Thank you for the invitation to comment on this PAC which outlines a proposal to replace an approved biomass plant with additional warehousing (Use Class B8 Use). I would also confirm receipt of a discussion note outlining the approach in Transportation terms in April 2021.

The proposal is to replace the approved biomass plant and 12,000m² of B8 with 50,000m² of B8 which would result in an additional 38,000m² of B8. There are a number of indicative internal layouts for the proposed development provided and one has been used as a possible example of the layout of development being proposed.

00 - Proposed Site Plan
1 : 2000

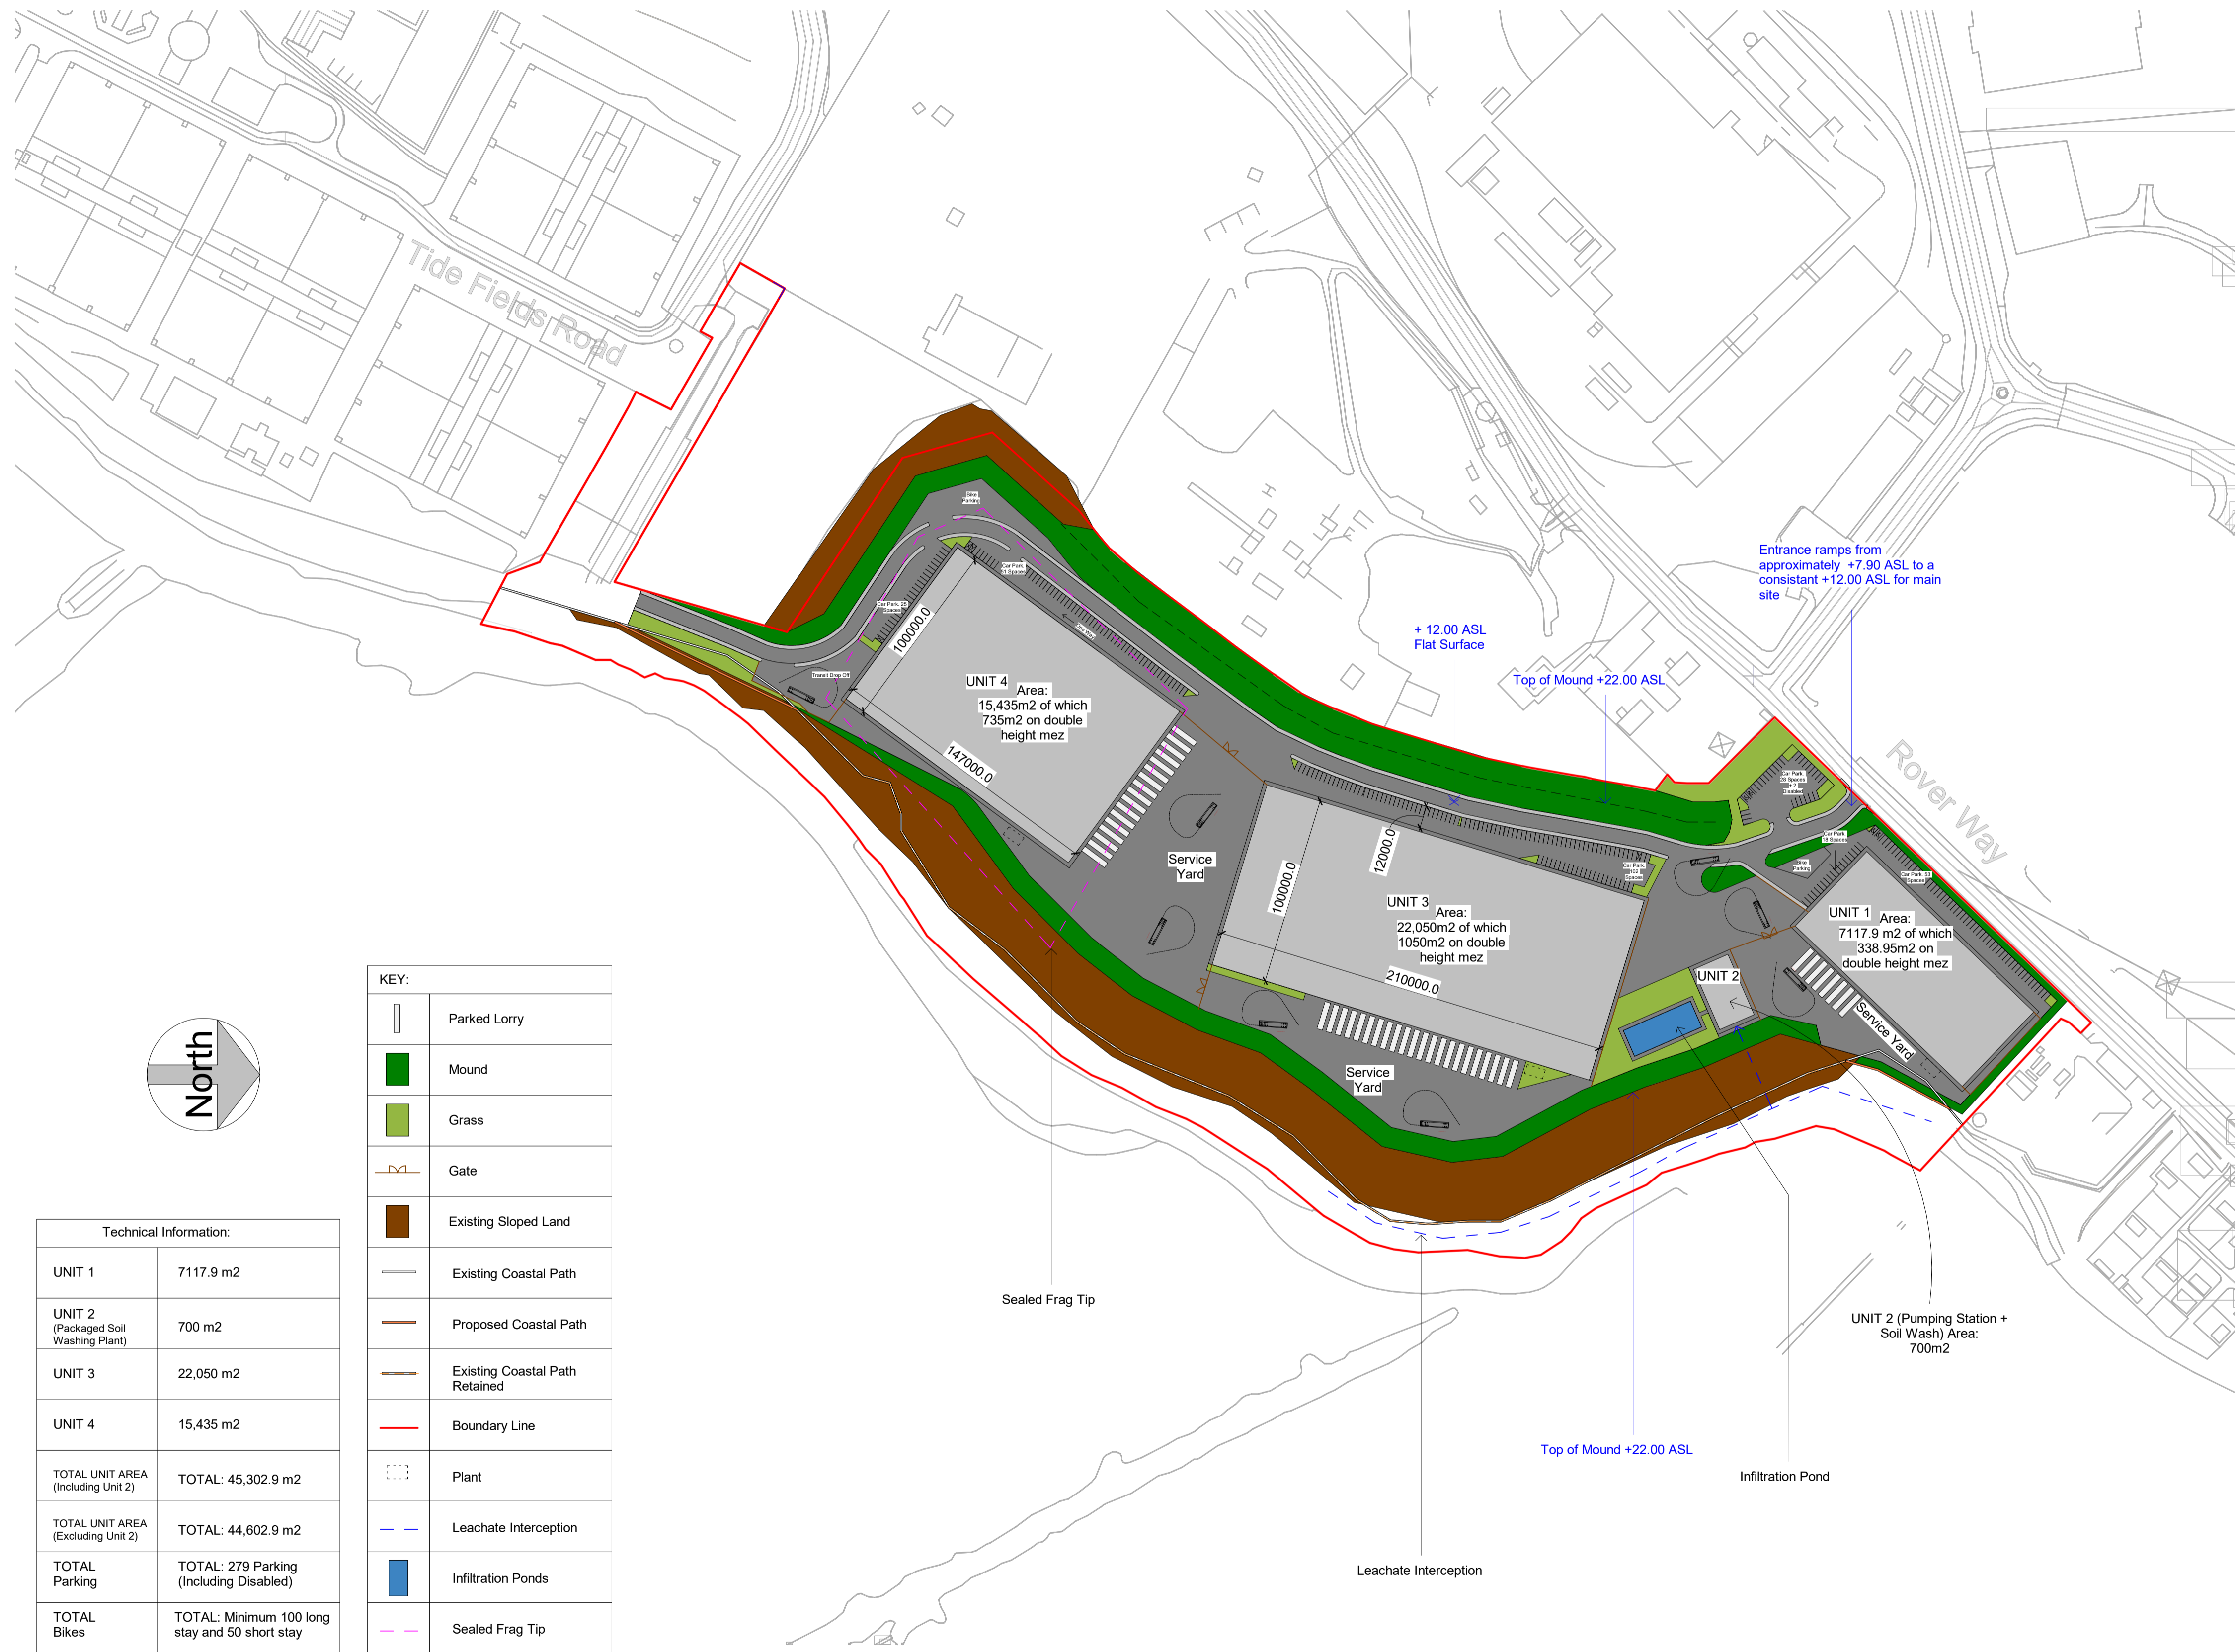
The applicant is proposing to retain the existing vehicular access via Tide Fields Road as well as the new approved priority junction with right turn lane on Rover Way. The new access arrangement off Rover Way has full approval to construct and it is illustrated that the junction would operate in an acceptable manner. It is noted that the PAC documentation provides no detail regarding the Tide Fields Road access, but it is noted this forms part of Cardiff Council's adopted highway and currently provides for all movements associated with the Welsh Water Treatment Works. It was also the access used by Cardiff County Council to accept over a million tons of fill material onto the site from the St Davids 2 development and the new Cardiff City Stadium and sports arena at Leckwith. As such, it is considered totally acceptable and satisfactory that Tide Fields Road can be used as an additional access to the site during construction and operation.

The PAC documentation indicates support for a number of policy documents, including PPW (ed 11), Wales Transport Strategy, Active Travel Act (Wales) 2013, Future Wales and the council's LDP, which rely upon the support of alternative modes of travel to a site. We recognise that the Transport Statement included in Appendix 9.1, within the PAC documentation, makes reference to the scheme is indicative at this stage and describes the reasoning for the difference in the SPG Parking Standards and that shown on the indicative layout. It is recognised that this is an outline application and this

matter will need to be the subject of more detailed discussion at the time of submission of a detailed application and supporting Transport Management Plan.
